The Member-Secretary,  
Madras Metropolitan  
Development Authority,  
No.8, Gandhi-Irwin Road,  
Egmore, Madras-600 008.

Lr.No. A3/17359/90

Sub: MMDA - Planning Permission - **Construction**  
of Residential building in Plot No.23A  
at R.S.No. 184/2 and 184/1 of Anakaputhur  
village - Approved - Regarding.

# PROPOSED RESIDENCE FOR THIRUMATHY. BALASARASWATHI ON PLOT NO 23 DEVARAJ NAGAR

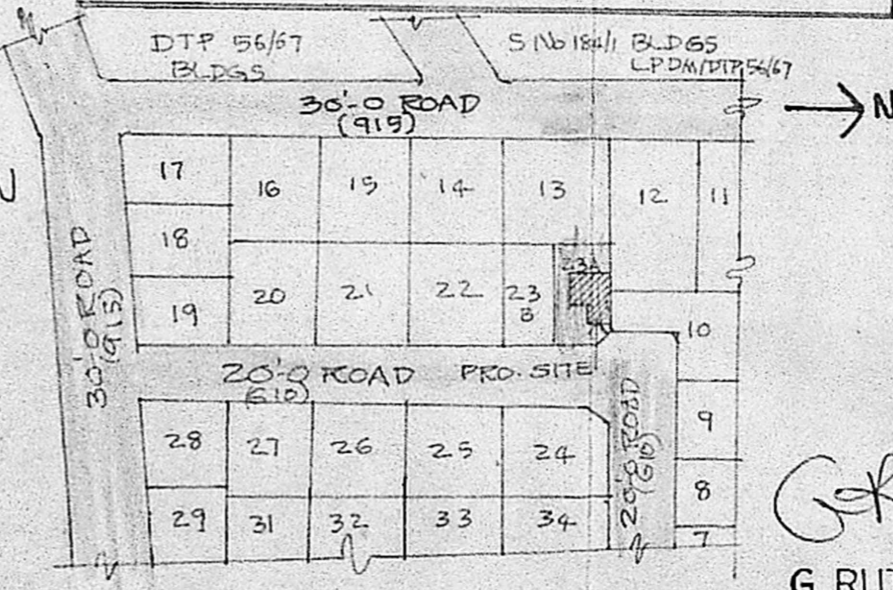
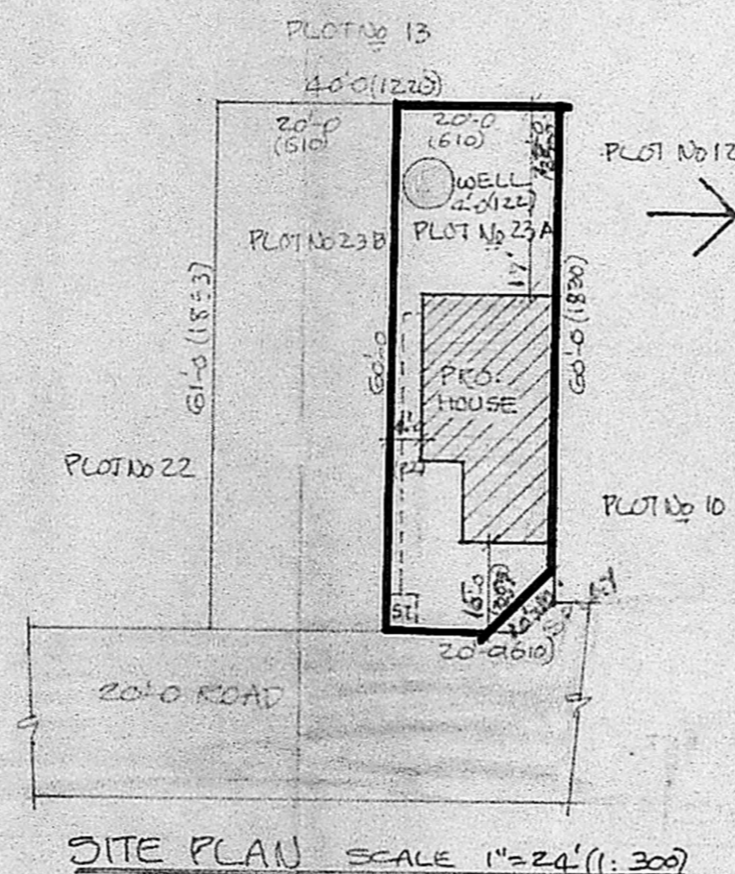
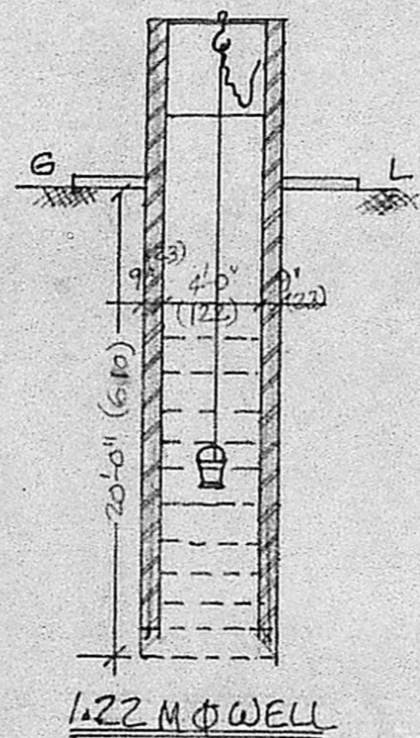
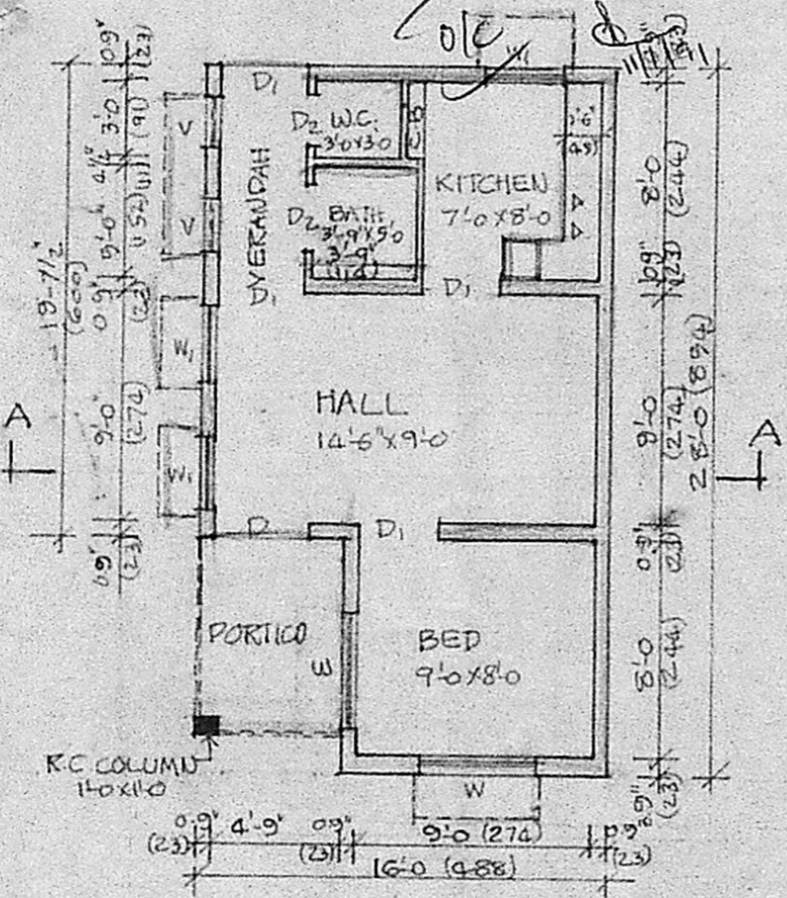
The proposal received in the reference cited for the construction of Residential building at Plot No.23A at R.S.No. 184/2 and 184/1 of Anakaputhur village has been examined and found approvable. You are requested to furnish the revised plan (Six plan) complying 3M x 3M splay and Plot No.23A.
